# CITY OF ALBUQUERQUE

October 9, 2012

**Re: Tuan Van Huynh Residence Grading and Drainage Plan  
Engineer's Stamp dated 08-25-12 (L-23/D001D)**

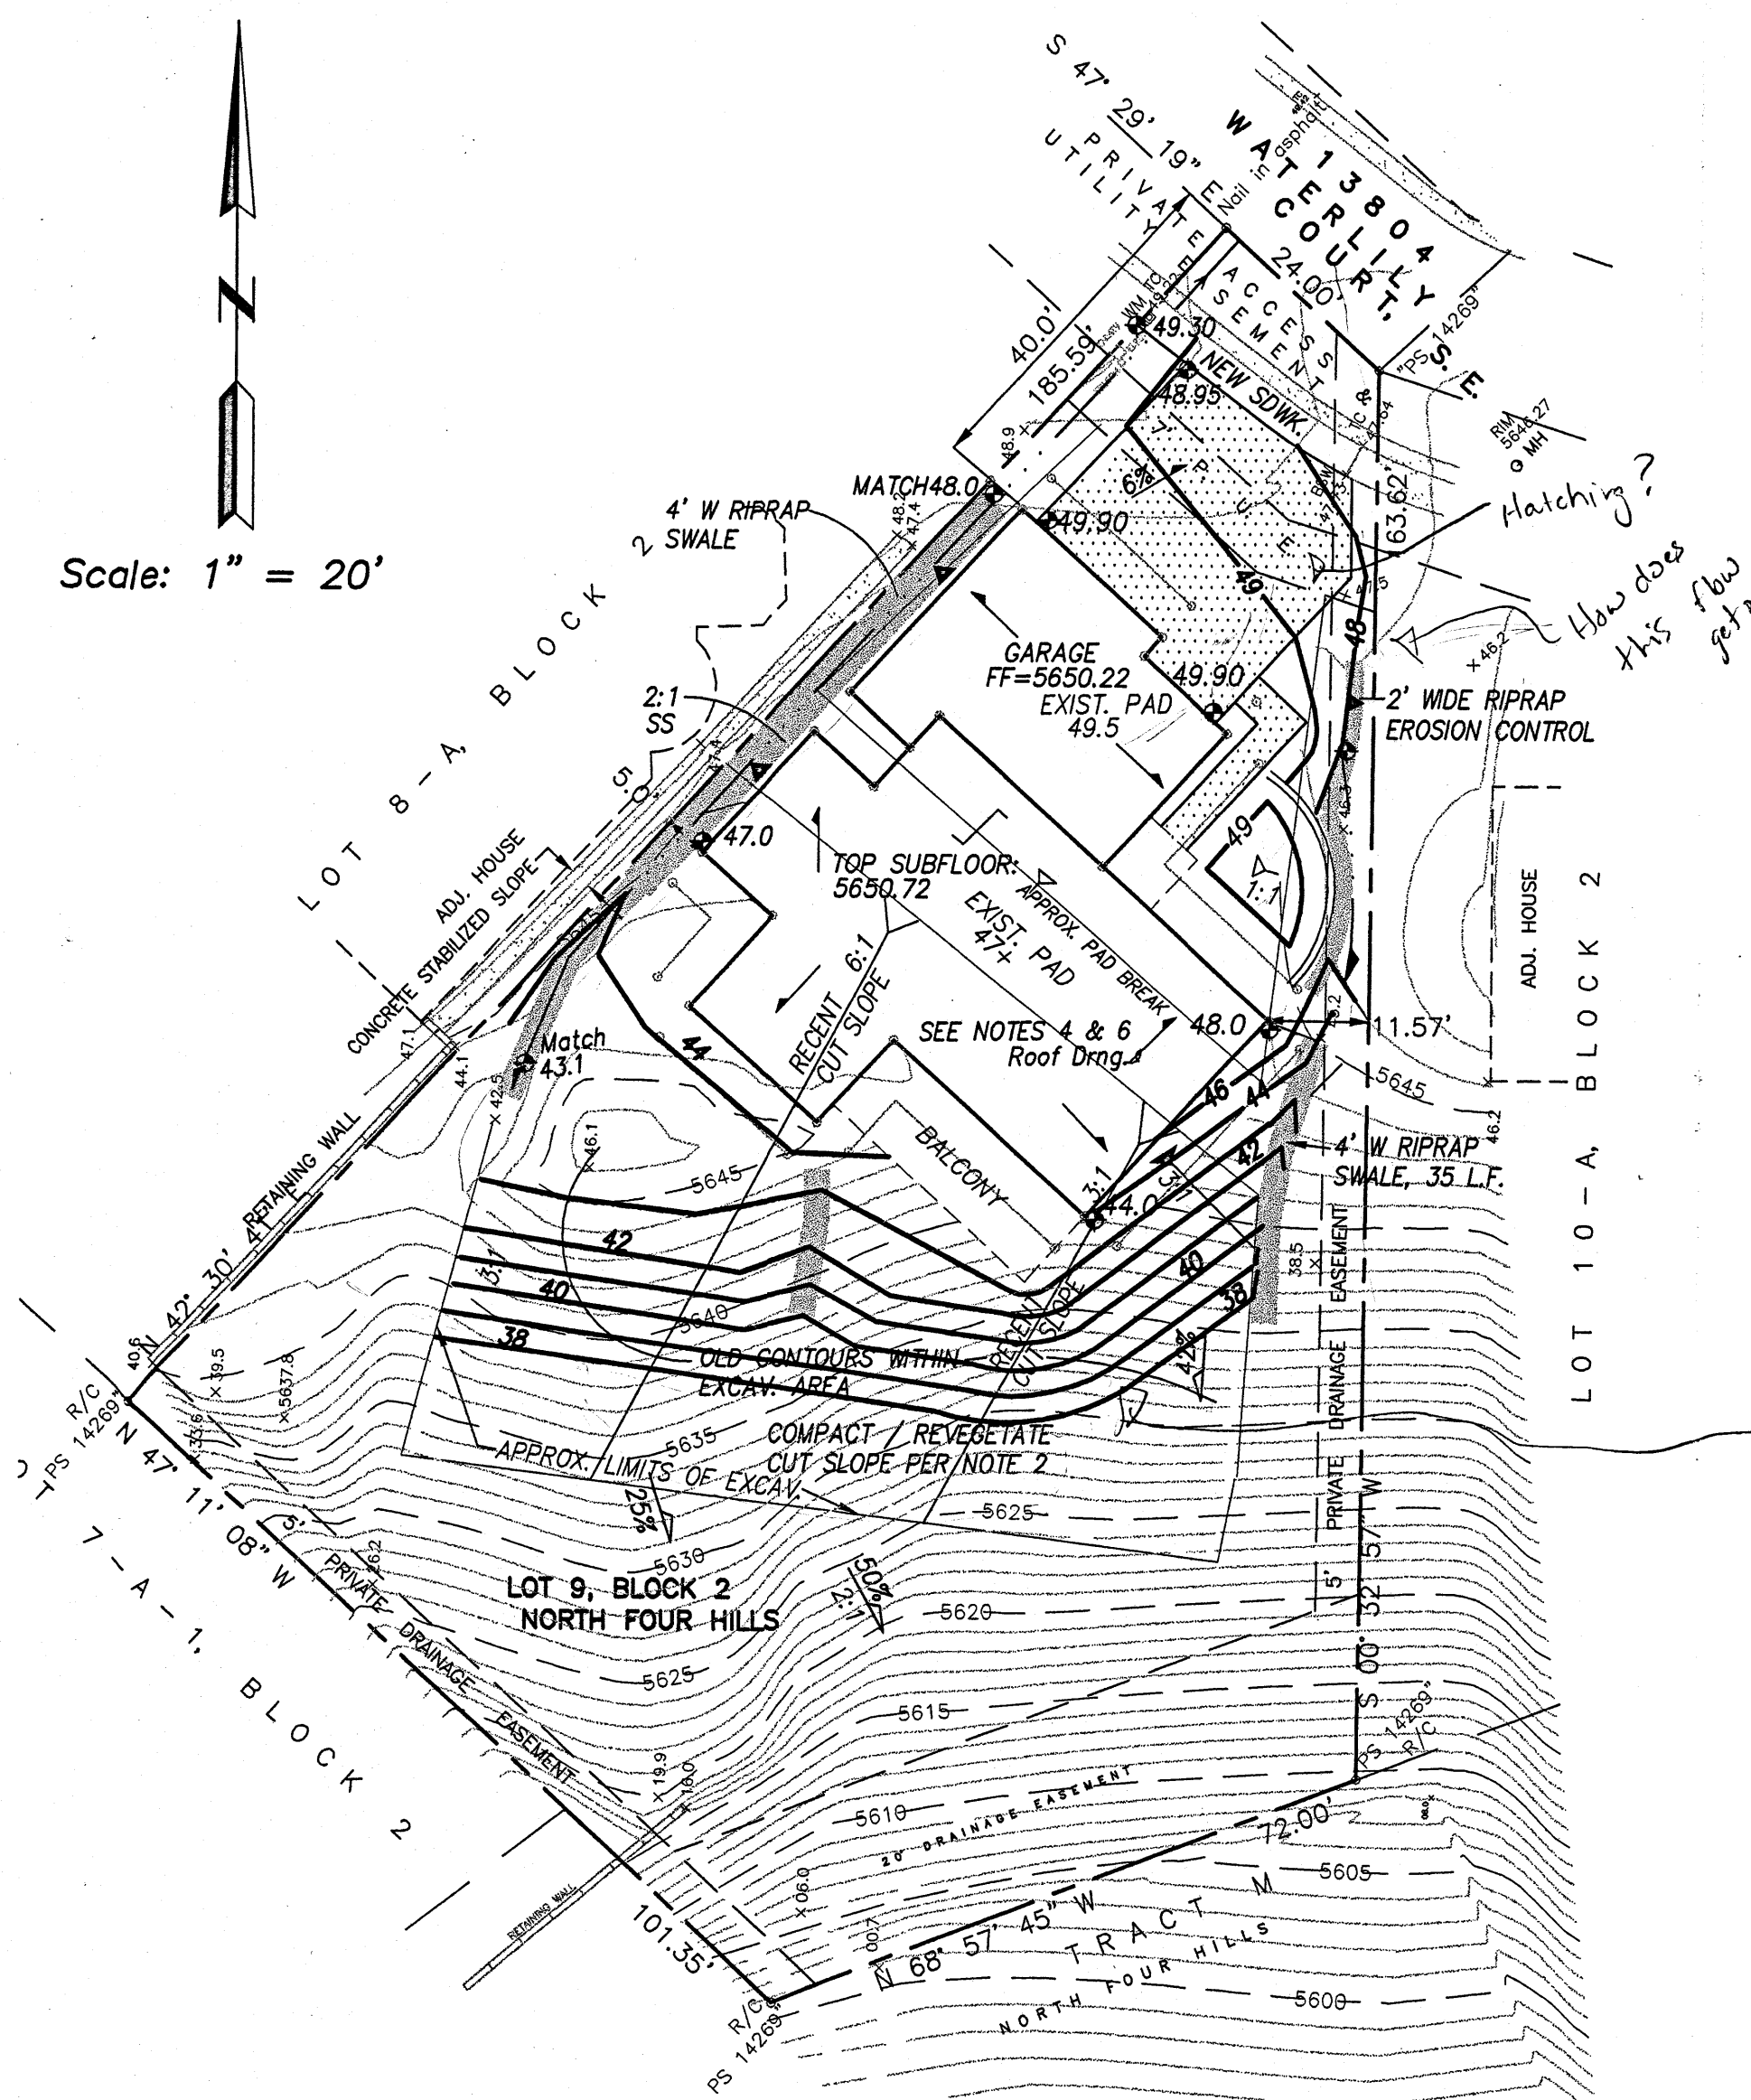
- Since the topography does not represent the exiting graded areas, as-built grades will be required.
- Slopes treatment will be needed for the slopes exceeding 3:1 grades.
- There is also an existing retaining wall within the 5' drainage easement along the southerly boundary. Need to make sure that this retaining wall will adversely impact the offsite runoff.

- The 38 ft. contour south of the balcony does not match up with the existing contour of 29 ft. It appears that a retaining wall will be needed along this contour.
- The spot elevation at the southeastern edge of the residence appears to be 3 ft. lower than the existing pad elevation of the home.
- There also appears to be a 4 foot drop around the southeastern edge of the footing for the balcony. How will this be addressed?

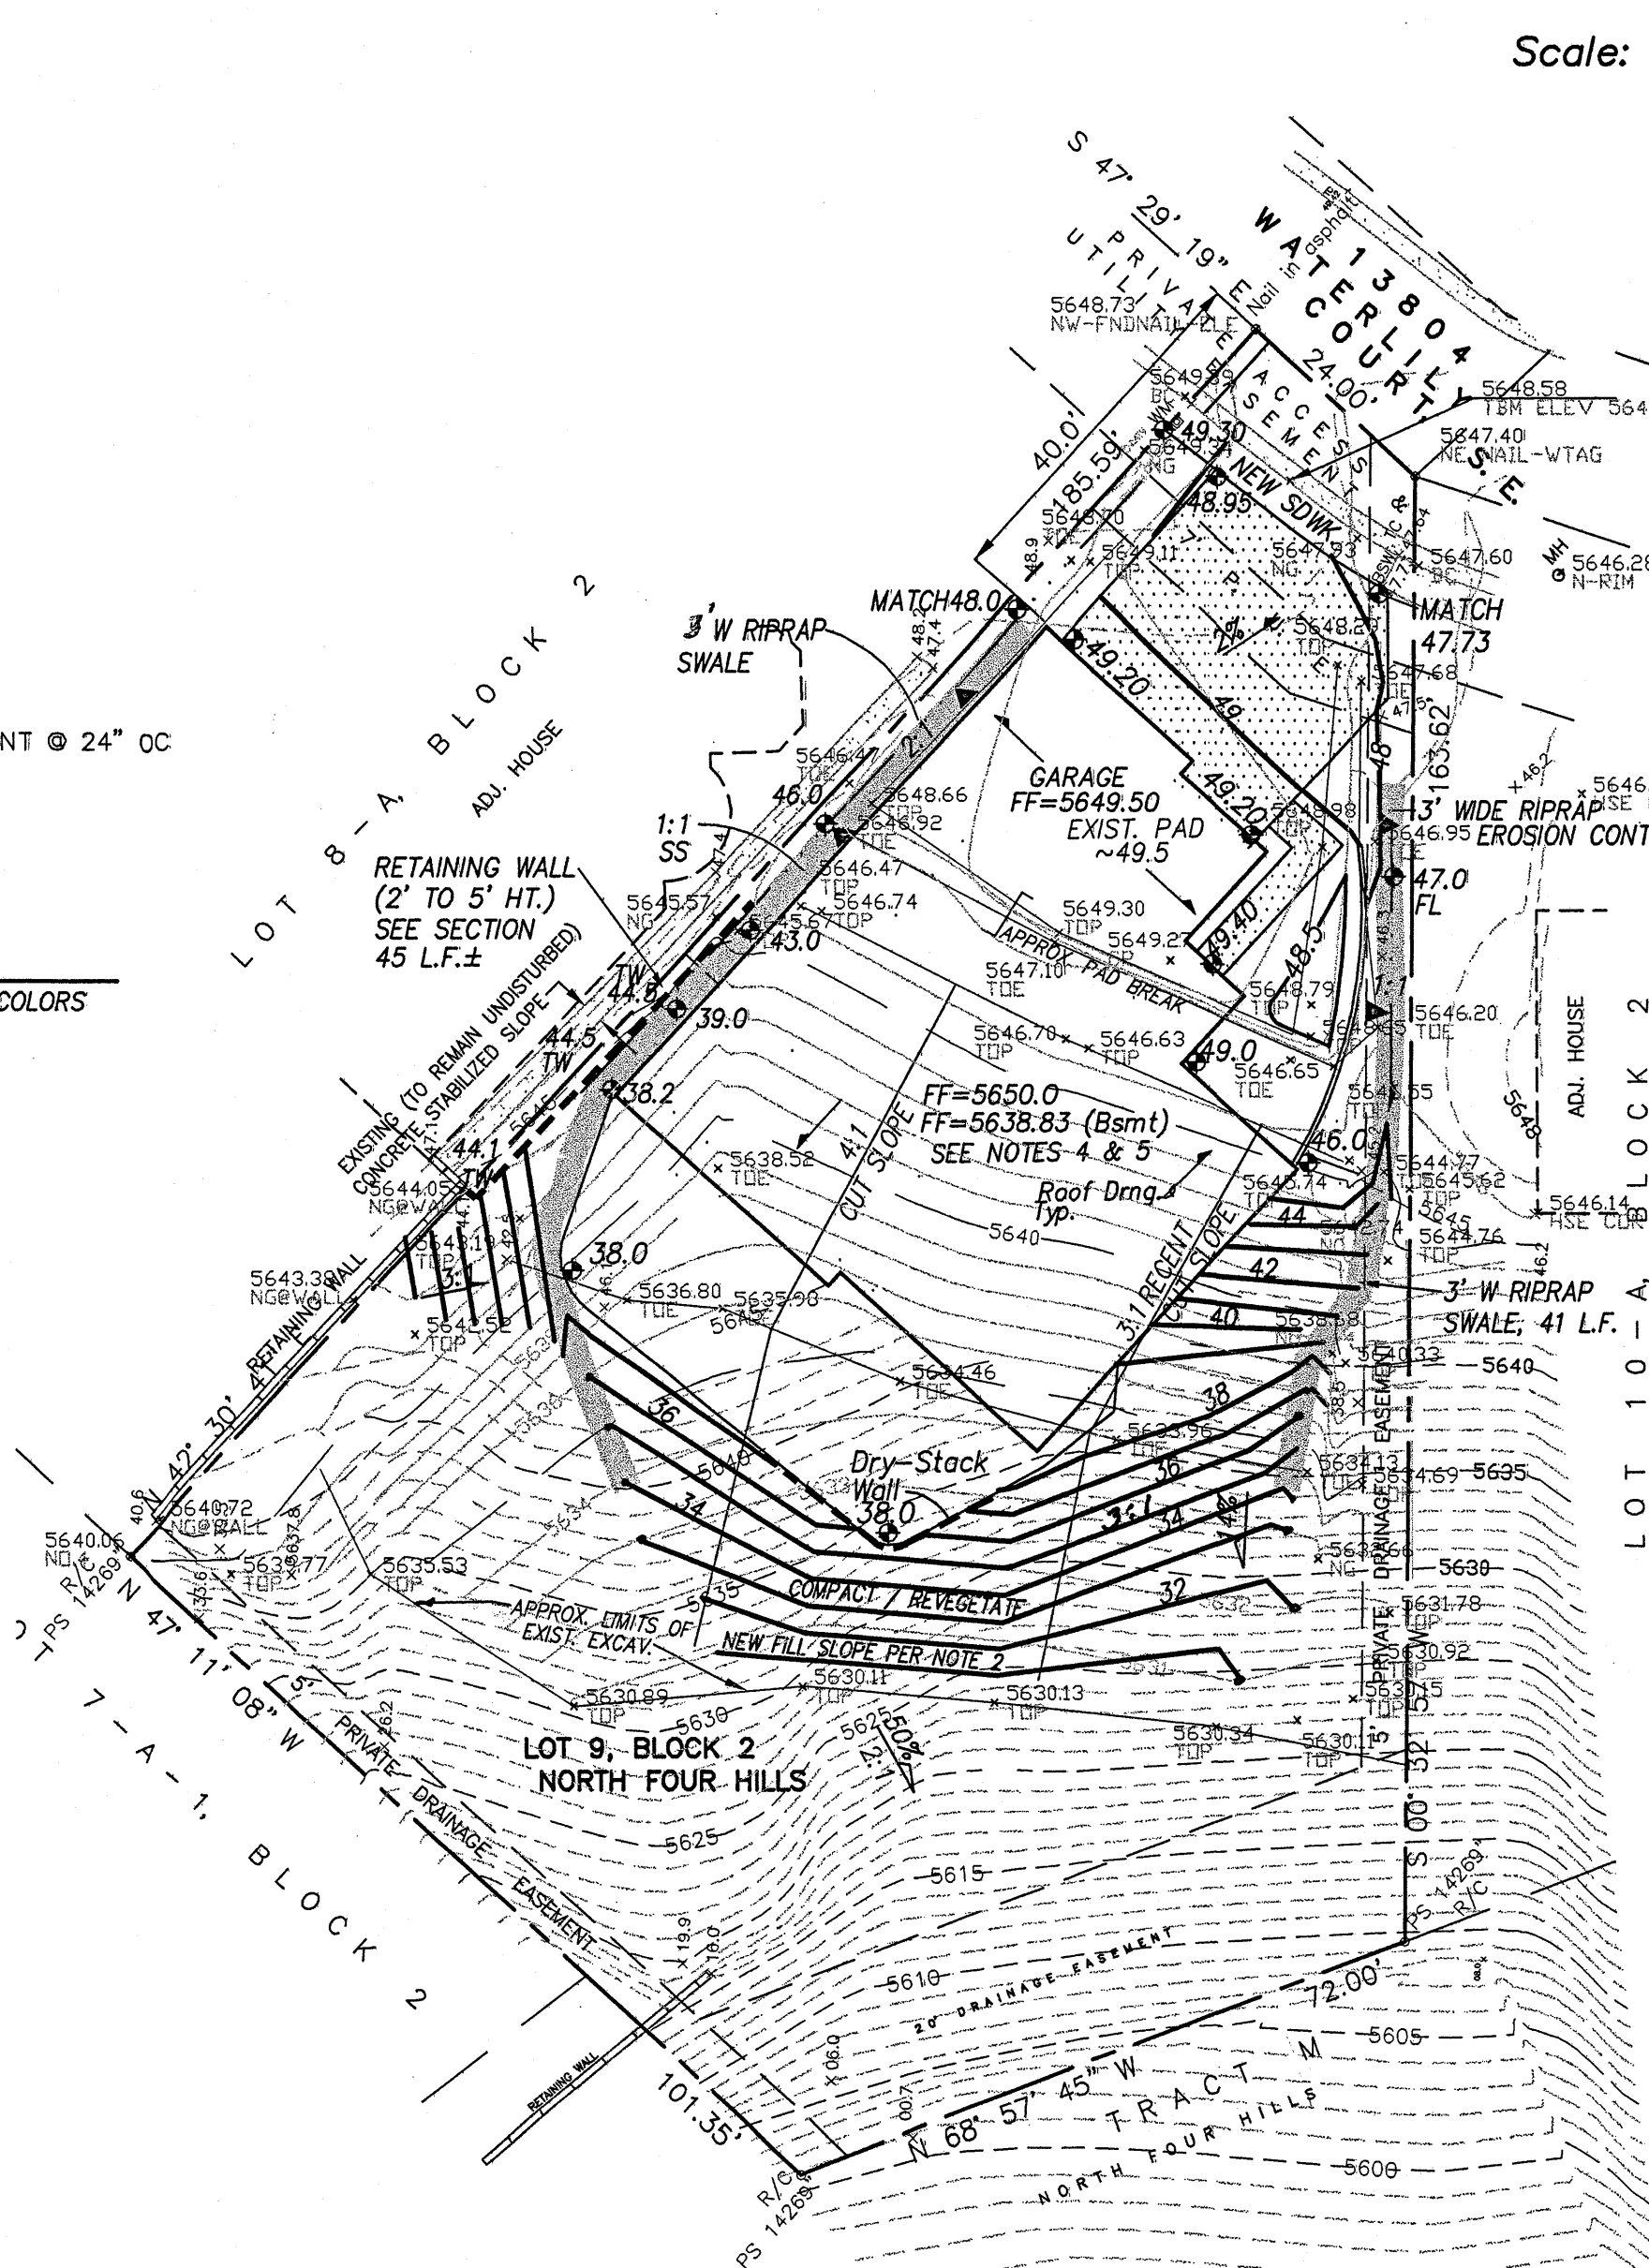
- Since the topography does not represent the exiting graded areas, as-built grades will be required.
- Slopes treatment will be needed for the slopes exceeding 3:1 grades.
- There is also an existing retaining wall within the 5' drainage easement along the southerly boundary. Need to make sure that this retaining wall will adversely impact the offsite runoff.
- No runoff should drain over the slopes to the south. The runoff from the constructed area should be intercepted by inlet(s) and piped to the bottom of the slopes.
- A variance will be required if the proposed wall shown on the plan exceeds 8' (retaining wall + garden wall).

Based on revised plan submitted on 9/28/2012 the grading and drainage is approved for Building Permit. Please attach a copy of this approved plan to the construction sets prior to sign-off by Hydrology. The following comments have to be addressed prior to Final Certification of Occupancy:
